**Diane Sarkies - Attention:Director, Infrastructure Projects EIS 2**

Re: Using Robert Rd as an access road. Application number SSI-5414

Figure 6.12 Cherrybrook Station - Indicative vehicle and pedestrian movements

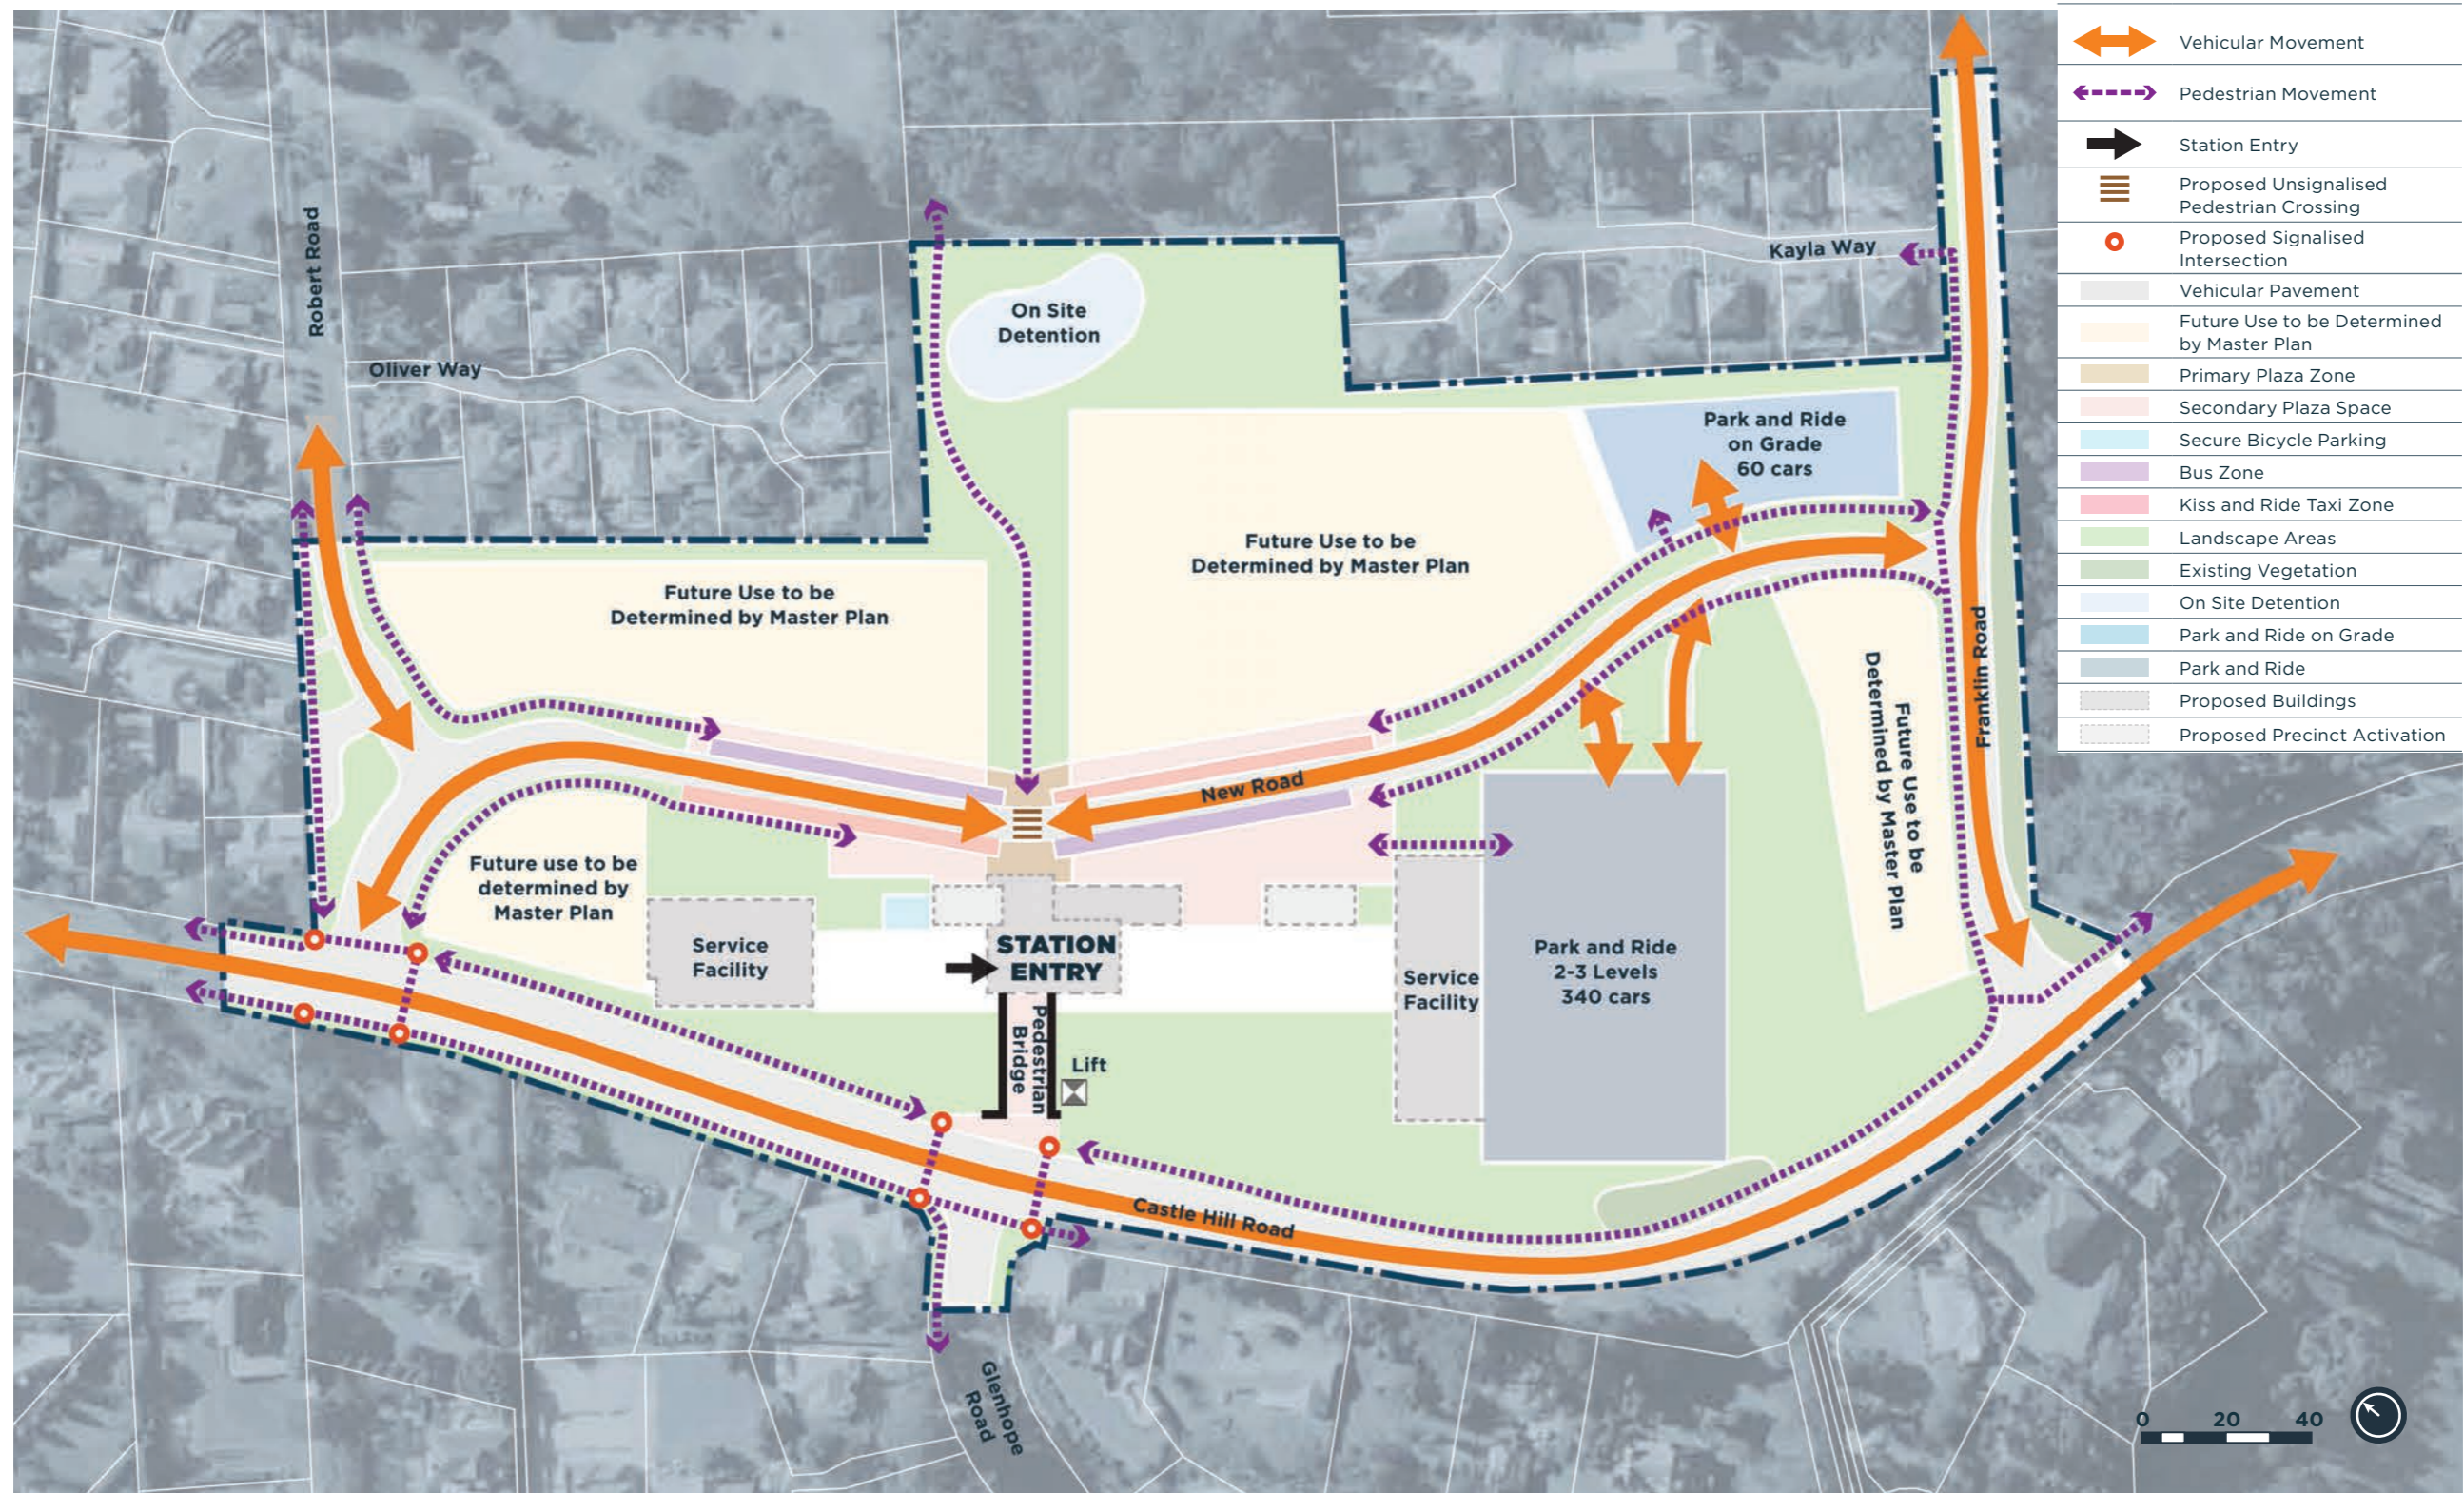
My family and neighbours are extremely unhappy and dissatisfied with the proposal in EIS 2 of the North West Rail Link to use Robert Road as an "access road" into the Cherrybrook Railway Station and we wish this submission to be read and our voices heard for the following reasons.

Robert Rd will become a sub arterial road for buses and cars to access and leave the station. This will make Robert Rd a very busy thoroughfare. It will also be no parking along its entire stretch. This will severely impact us all and send traffic into our peaceful **narrow** street, trying to park, where there is **no** place to park. The roads were not designed to take this load. It will prevent us getting out of our driveways and clog all the surrounding streets. The congestion will be unbelievable, dangerous and unworkable. Gridlock and frustration will result and be a daily occurrence!!! I'm sure the media could have a field day. There are many school children who will be placed in hazardous conditions trying to walk to school.

*1. Buses to head south on County Drive and continue up towards Castle Hill Road , turn left into Castle Hill Road and head towards the Cherrybrook Station INSTEAD OF the NWRL proposal of buses to head south on County Drive, turn left into John Road and right into Robert Road and head south up Robert Road into the Cherrybrook Station",*  
 the NWRL indicated that this would mean that those residents on John Road and Franklin Road would now not be able to catch the bus to the city, unless a second set of buses and bus routes were established. Instead, the NWRL stated that under their proposal of running buses left into John Road from County Drive and **then** right into Robert Road would only see a small proportion of residents on John Road and Franklin Road who currently catch the bus into the city, being effected without the need for a second set of buses and bus routes.

2. *Buses to head south on County Drive and continue up towards Castle Hill Road , turn left into Castle Hill Road and head towards the Cherrybrook Station INSTEAD OF the NWRL proposal of buses to head south on County Drive, turn left into John Road and right into Robert Road and head south up Robert Road into the Cherrybrook Station”,*

As a result, to avoid any buses being caught in this anticipated traffic, the NWRL have proposed buses to run left off County Drive into John Road and then right into Robert Road.

- a. County Drive and Castle Hill Road are built for the purpose of handling large volumes of traffic and large heavy vehicles (ie: buses). They do not have the traffic hazards and weight restrictions that the narrow suburban street of Robert Road has.

- b. Traffic currently heading south up County Drive to Castle Hill Road is free flowing in the mornings between John Road and Castle Hill Road. Shortly after John Road, County Drive, heading south, expands into 4 lanes as traffic approaches the intersection of County Drive and Castle Hill Road.

- c. There is rarely any traffic congestion when travelling east down Castle Hill Road towards Thompson's corner, until Edward Bennett Drive. The traffic congestion occurs generally only up to Edward Bennett Drive as the congestion is created due to Thompsons corner at West Pennant Hills

- d. There are no driveways as residences back onto County Drive so no safety concerns.
